LU/240/20/PL

Felix Dancewear 39 Beach Road Littlehampton BN17 5JA - Demolish existing out buildings & replace with rear extension

Dwg. No.	Rev.
BEA/001	A

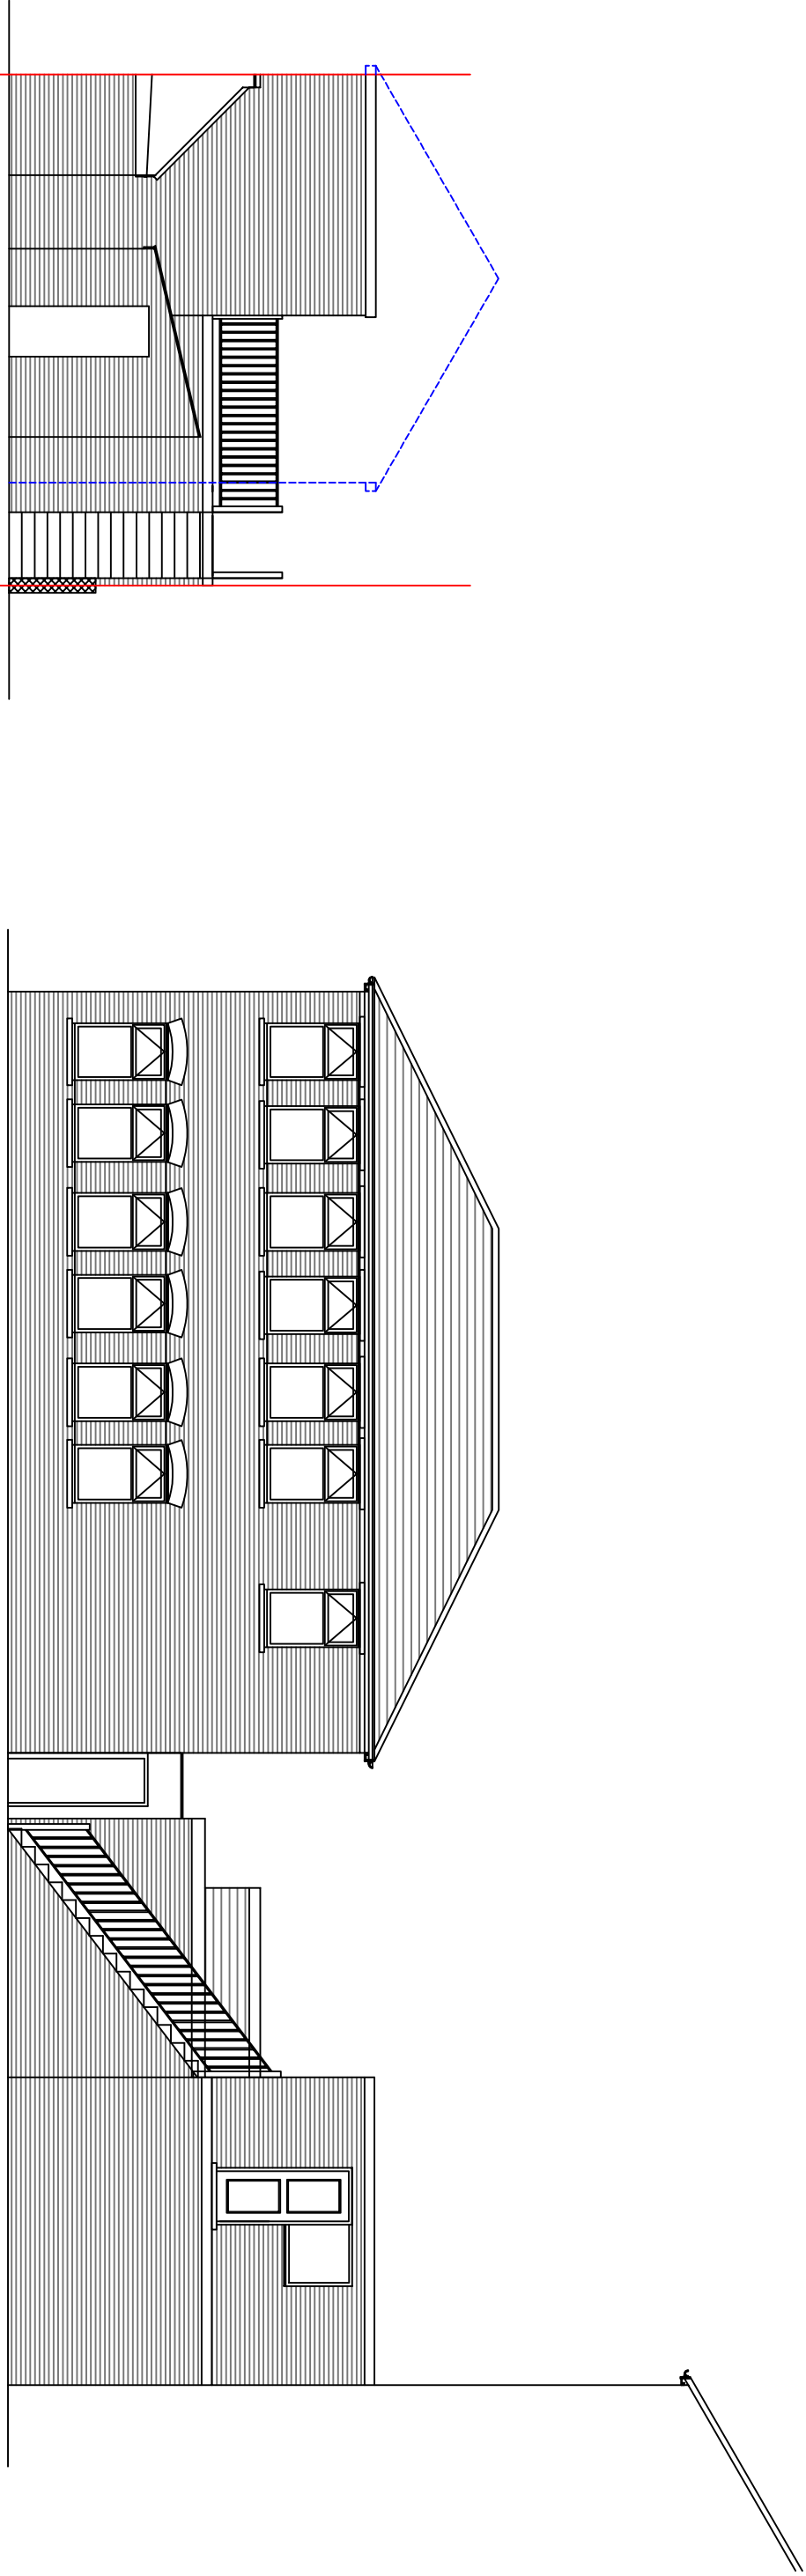
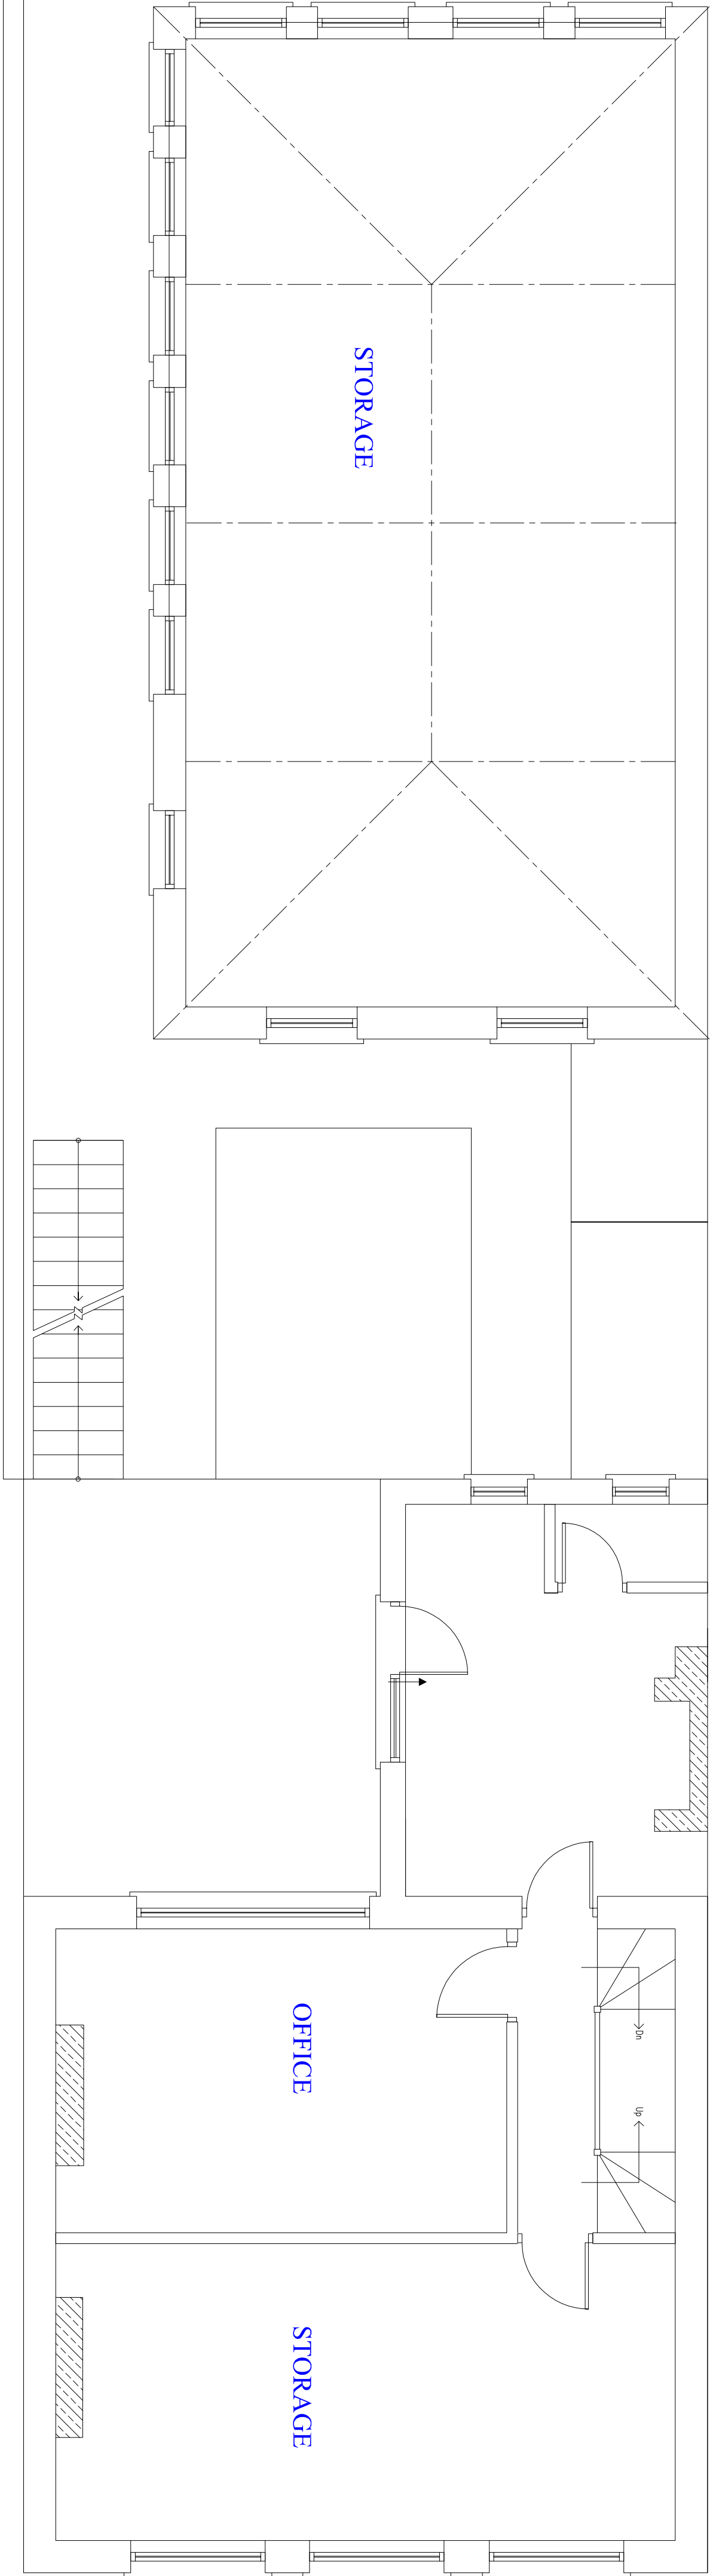
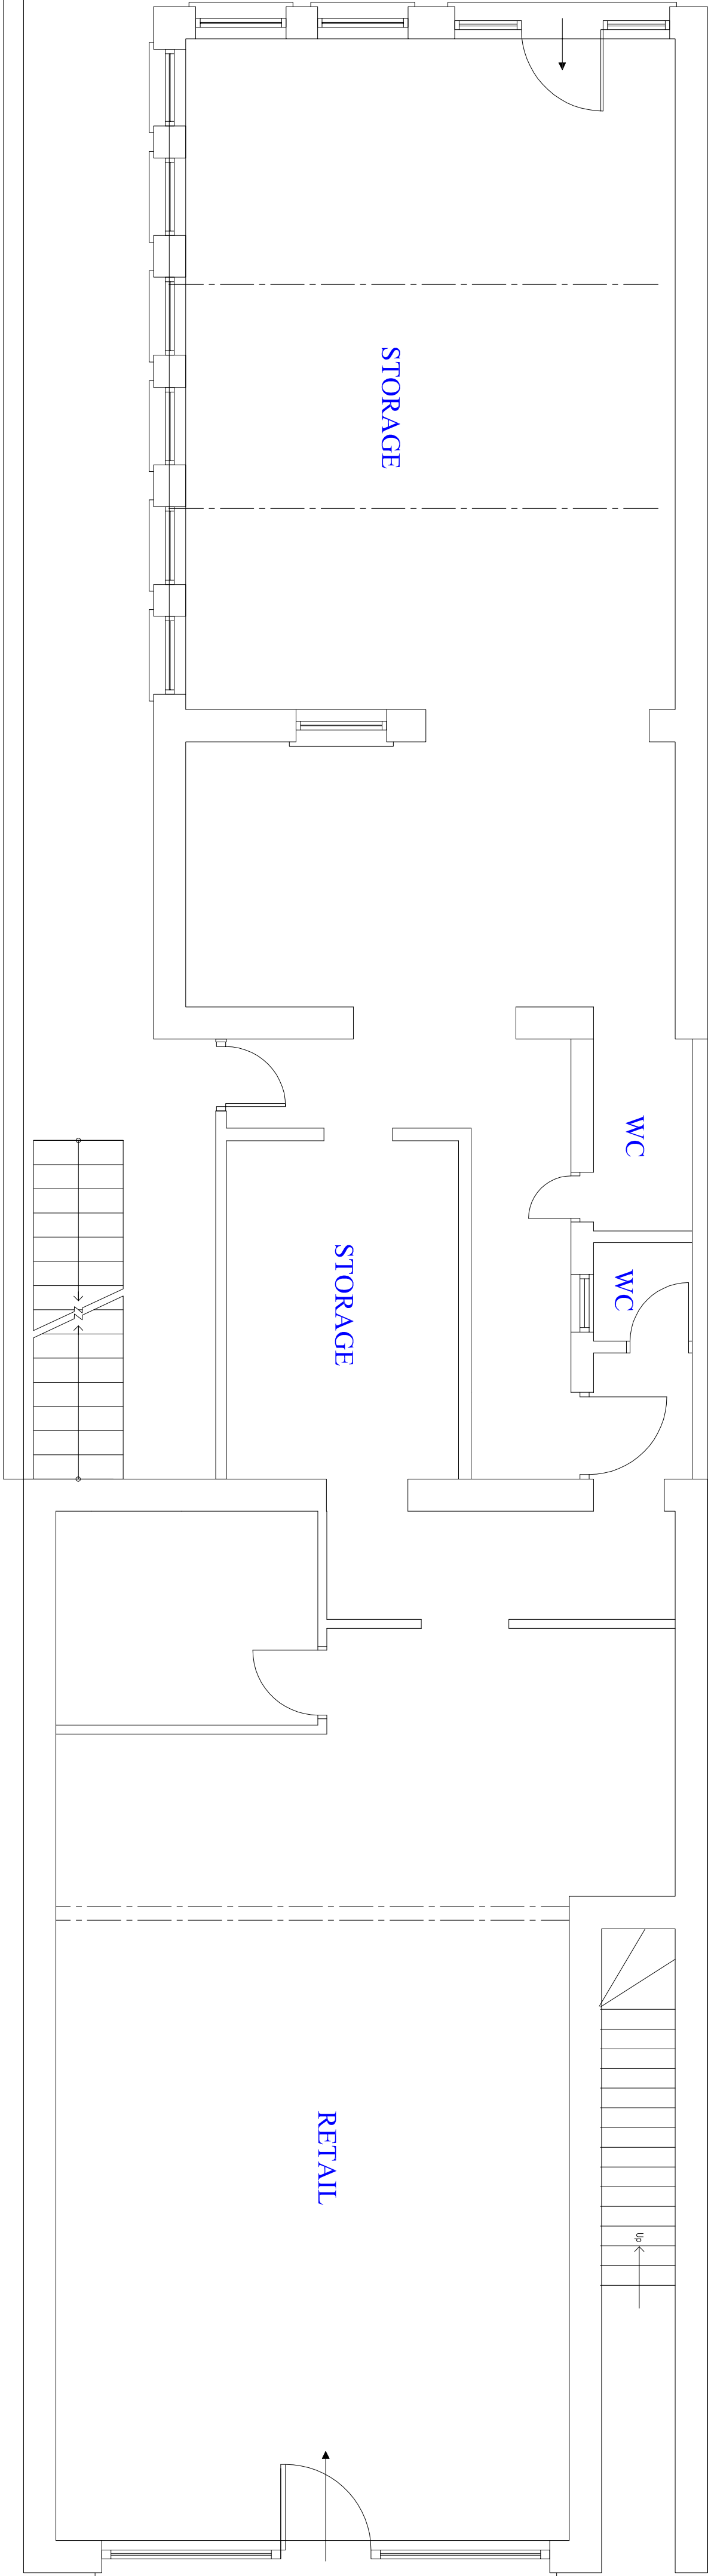
The proposal is for the demolition of an existing outbuilding and its replacement with a rear extension. This new space will provide for additional storage area for the retail unit. The existing outbuildings are positioned in such a location that they are not clearly seen from the car park to the rear of the building. They are also of a simple utilitarian appearance, which includes

corrugated sheeting. As a consequence, their loss will not harm the character of the building. Further, it is also considered that the replacement extension will have a neutral impact on the building due to its location and simple appearance. This is, of course, subject to the use of appropriate materials. The application should therefore be determined in accordance with the relevant policies within the Development Plan, along with these comments.
